Recommendation Report for Planning Permission for Works or Extension to a Dwelling

REF NO: EP/101/21/HH

LOCATION: 35 Roundstone Crescent
East Preston
BN16 1DG

PROPOSAL: Erection of single storey rear, part two storey side and front porch extension

Project: Proposed extension; 35 Roundstone Crescent, East Preston BN16 1DG	
Drawing: Proposed ground floor	
For: Mr. P. Windsor & Ms. A. Finch	
Drawn: PKS	Date: June 2021
Scales: 1:50	No: 2743/01/03
To scale when printed on A3

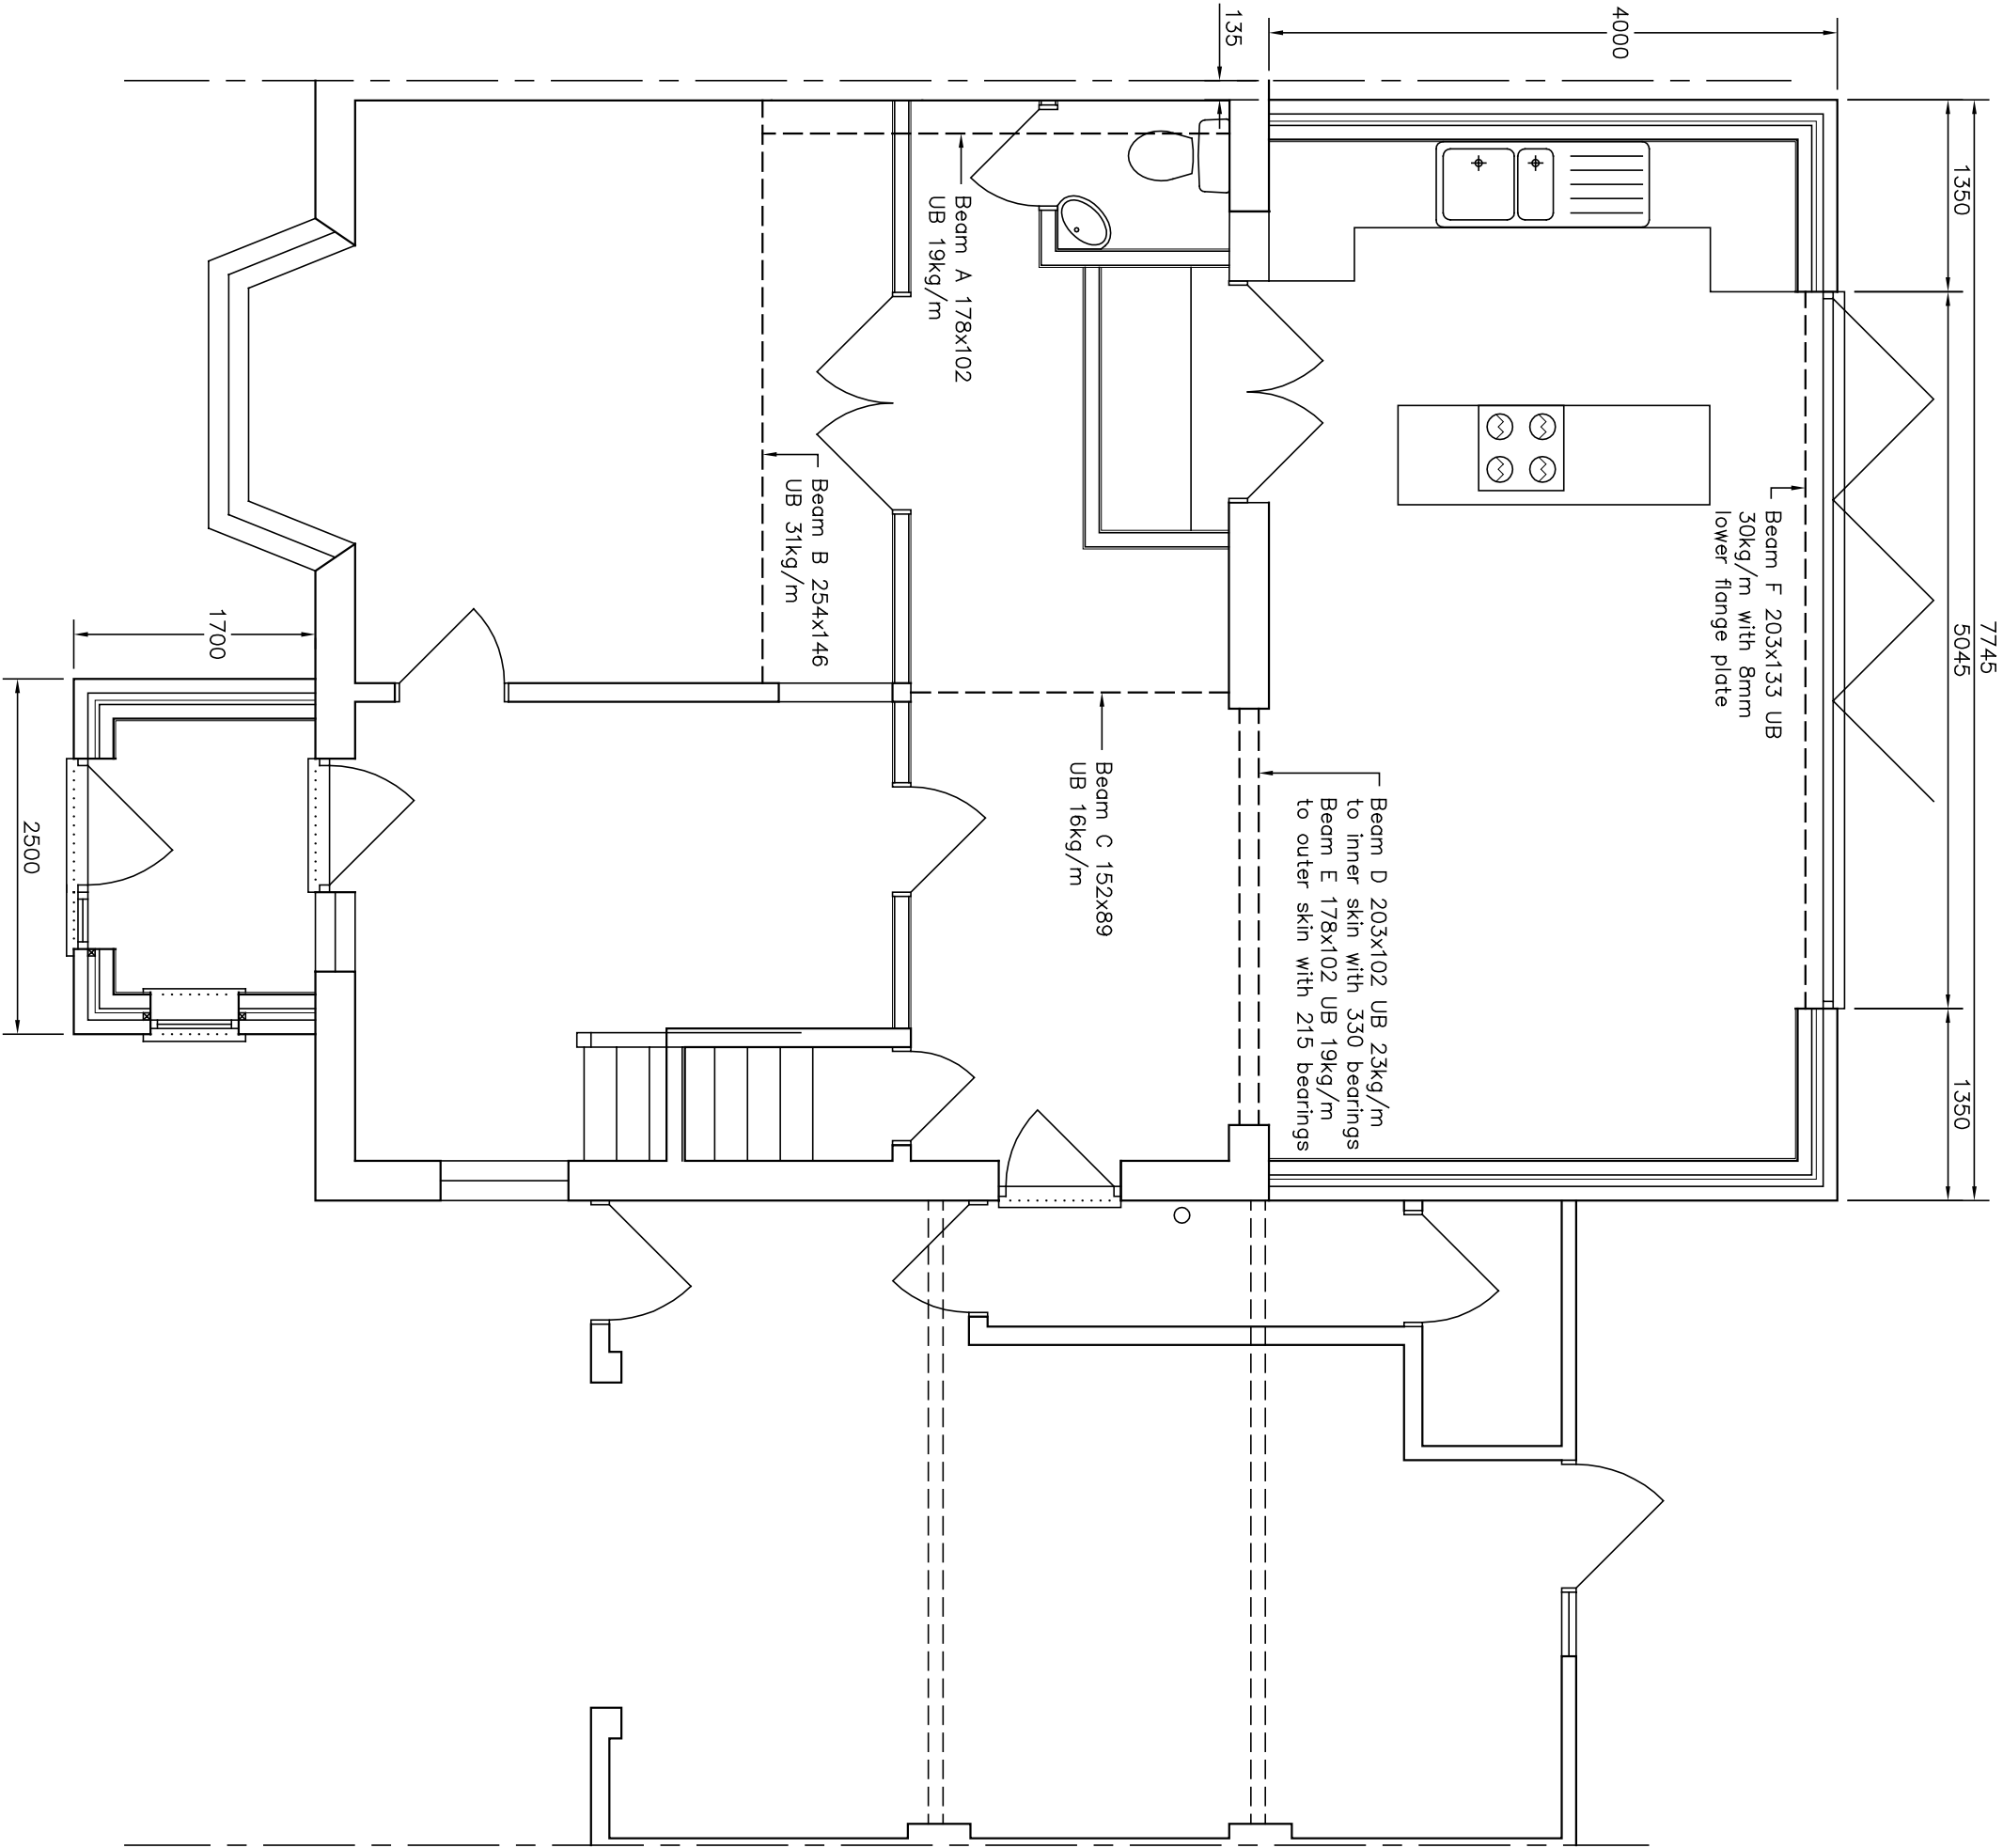
The rear extension is equally subservient due to its scale as a ground floor extension and is not visible from the street.

When considering the 45-degree rule the first-floor extension accords with guidance in that it will be built no further forward of the rear building line of the neighbour to the east. Similarly, the rear extension will be built with its rear elevation protruding no further than the (nearest) neighbours to the west, who have also extended their property across the rear.
